**From:** Melanie Latham [redacted]  
**Sent:** 15 November 2011 10:51  
**To:** Peter Cleveland  
**Subject:** RE: Arundel - St. Mary's Hall

On that point, the client has now confirmed all the changes to the building that are slightly different to the original planning application and I am shortly going to submit the drawings for the revised external areas for St Mary's Hall. There is no route for submitting an application for a non-material amendment via the planning portal, so I wondered whether I can send you the form and drawings electronically instead? I can certainly submit the listed building application online if this would be easier for you, alternatively, I could send this to you the same way. This application would be similar to the planning application, but include details for the internal arrangements (lift and staircase) and sectional elevations showing panelling in the hall. Perhaps you could let me know which you would prefer?

EAST ELEVATION

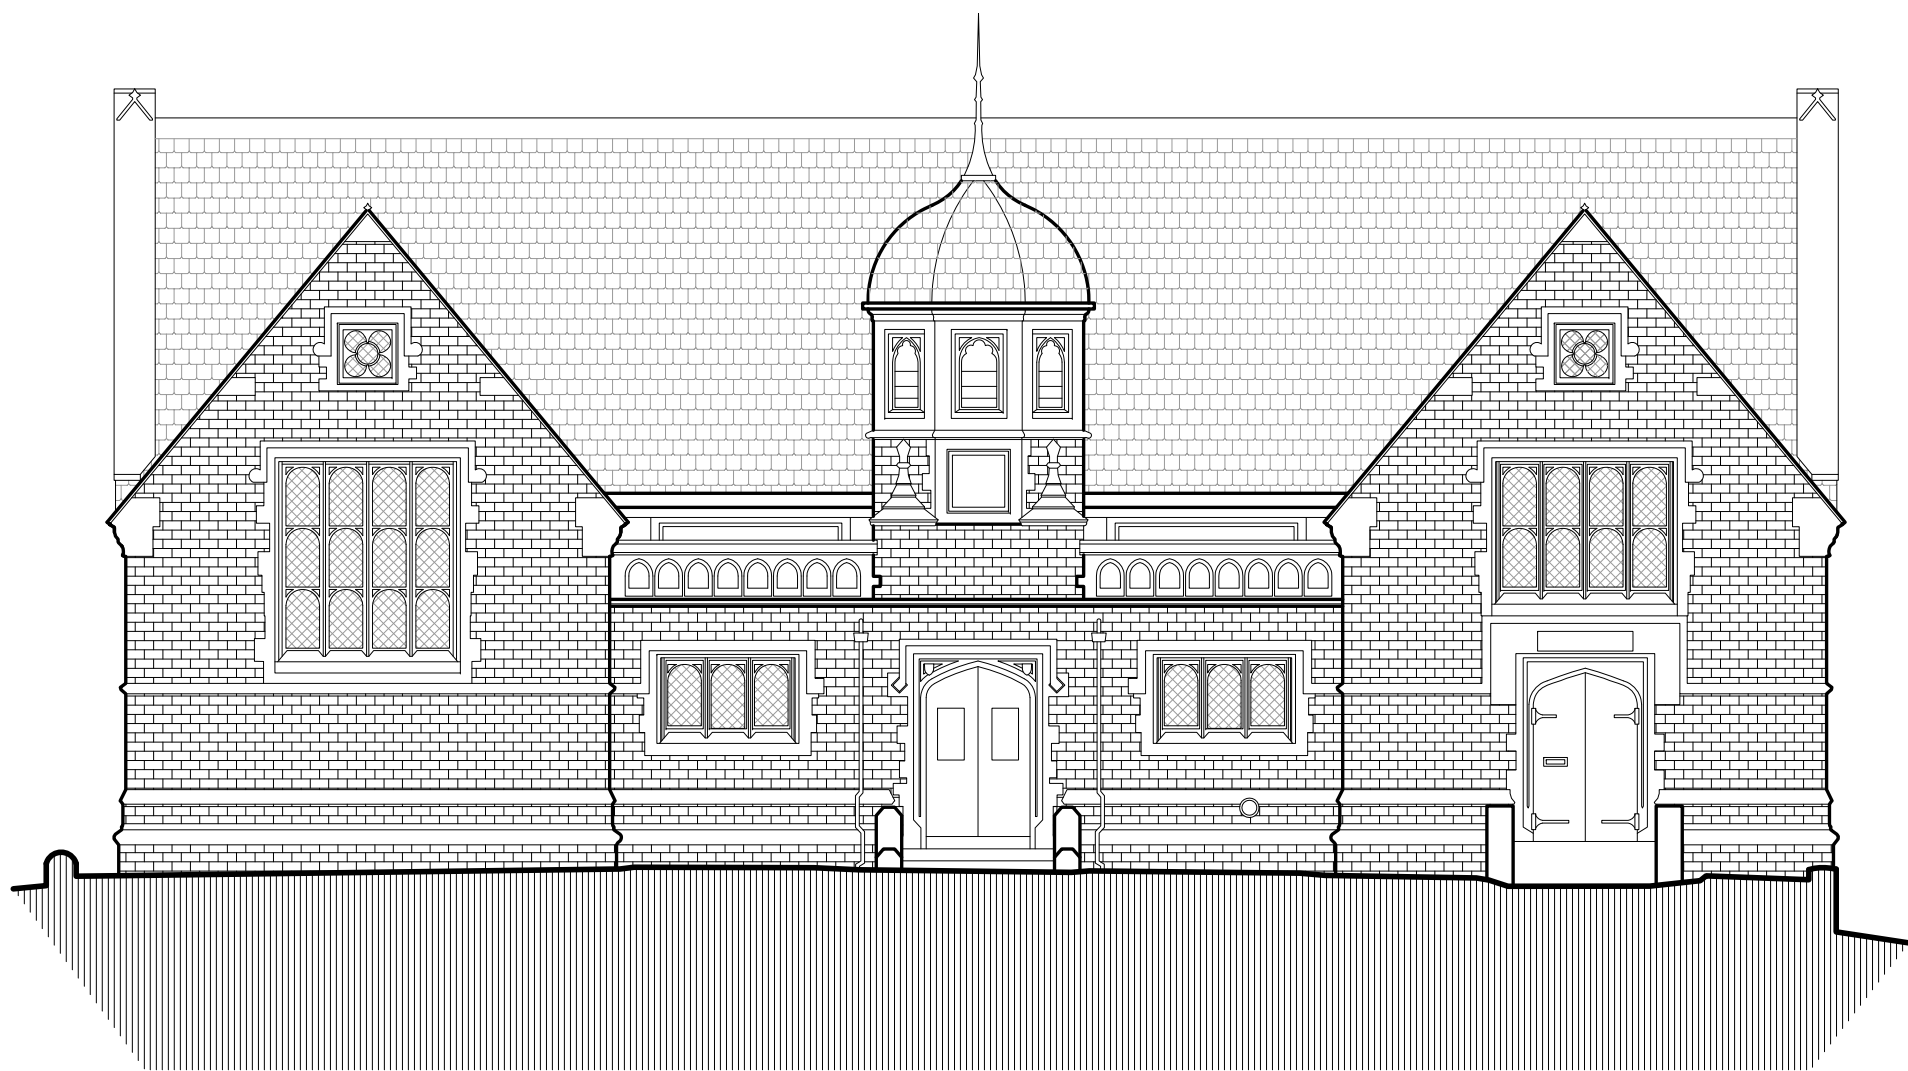
I think the proposed changes would be acceptable, however this is without prejudice to any subsequent planning application or listed building consent. I would however suggest that the railings be of traditional design and not to high/dominant along the eastern boundary of the site to ensure a minimal impact upon

I am still of the view that some form of restraint is required for the reasons given previously. The provision of 2 No. additional bollards of the type already proposed for the remainder of the frontage to London Road would not, in my opinion, appear excessive.

Your point about the railings is noted - we think that the metal railings would be the neatest and least obtrusive barrier, as they are quite slender and we can choose a traditional design to fit in. We would be happy to talk it through with you further once you've had the application details in full, if you have any concerns, however.
